CITY OF ALBUQUERQUE
PLANNING DEPARTMENT
Hydrology Section
Predesign Meeting Conference Notes
DATE: 12/15/14

ADDRESS: 7201 Central NW

DRAINAGE FILE: K10D015

PROJECT SCOPE:

LEGACY CHURCH WEST ACCESS ROADWAY DRAINAGE PLAN

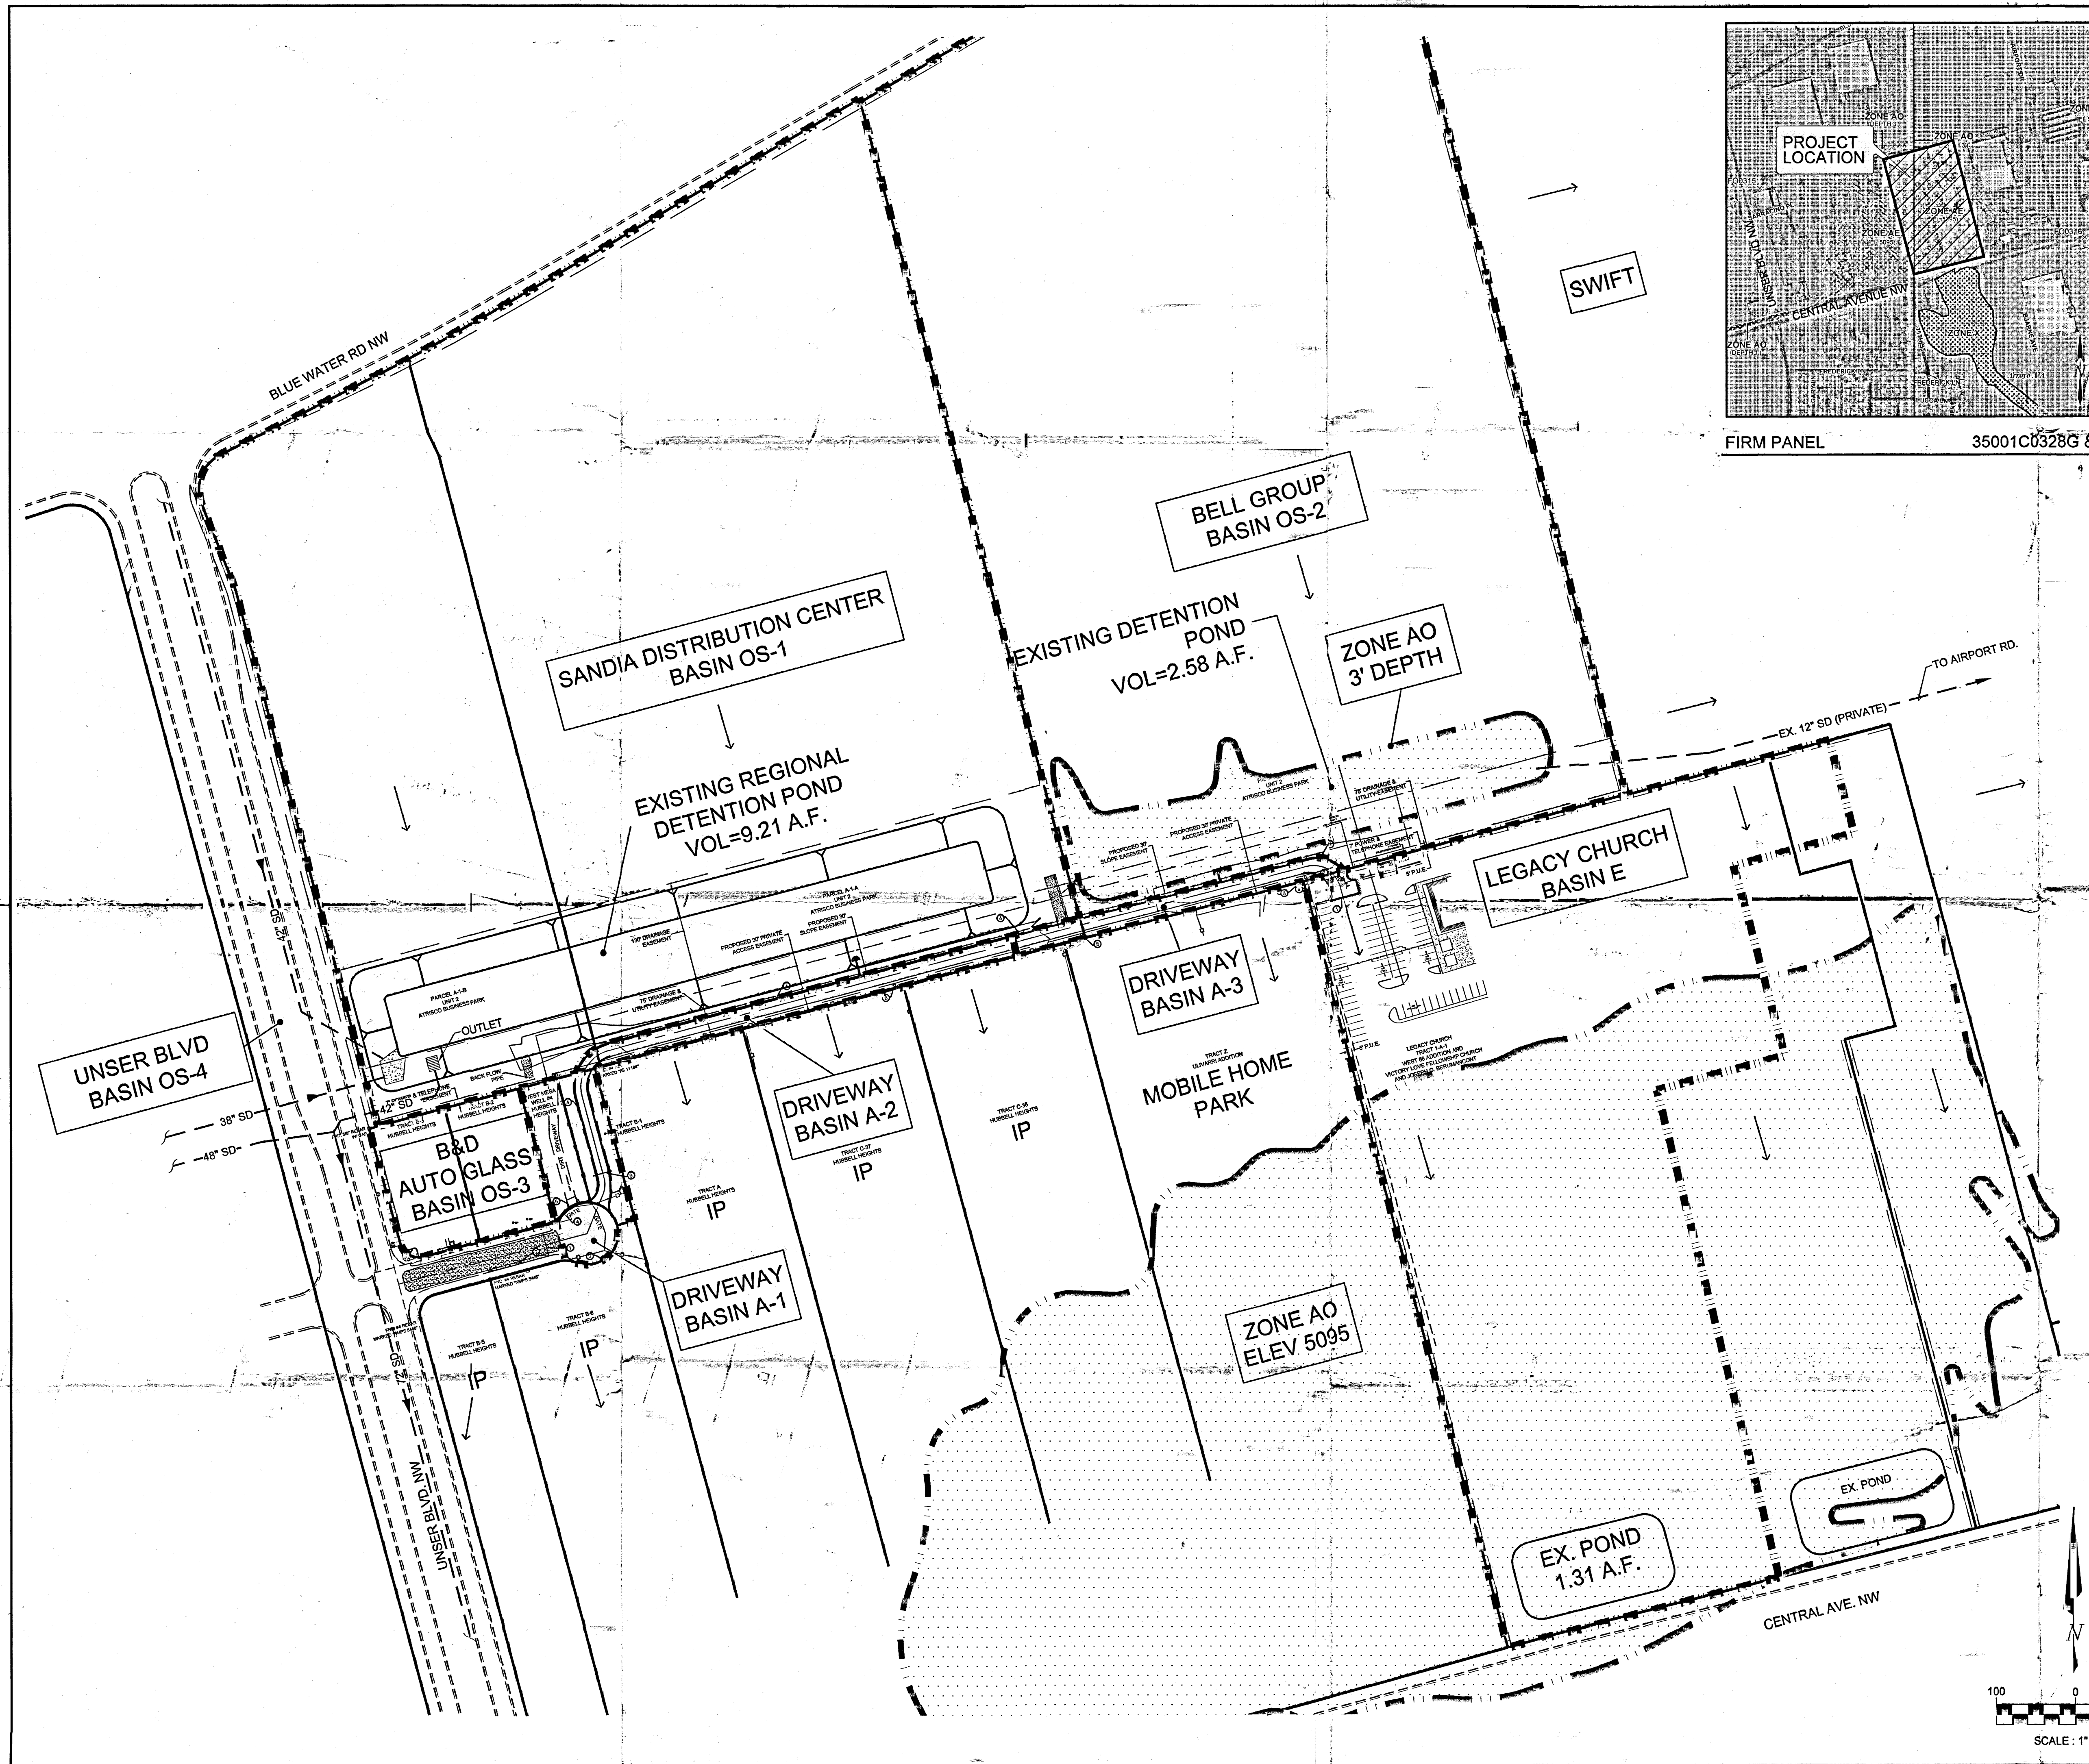
1. Vacate the public and private drainage easements on the Sandia Distribution Center and Bell Group properties. Provide new easements for the public and private drainage ponds and for the private roadway. The drainage easements and private roadway easements should not overlap. This will also necessitate an Administrative Amendment due to the IP and SU-1 zoning.

2. Provide topo of the existing pond on the Sandia property and on the Bell Group property. Base existing volume off of this topo. Base proposed flows on 100 year, 24 hour storms. The detention ponds are being partially filled by the design for the road. Modify detention ponds so that enough volume is provided for the change due to the road and for the additional flows. We will accept a design flow of 9.5 ac-ft for the Sandia detention pond. Include excerpts from the Atrisco Business park MDP discussing the Sandia pond.
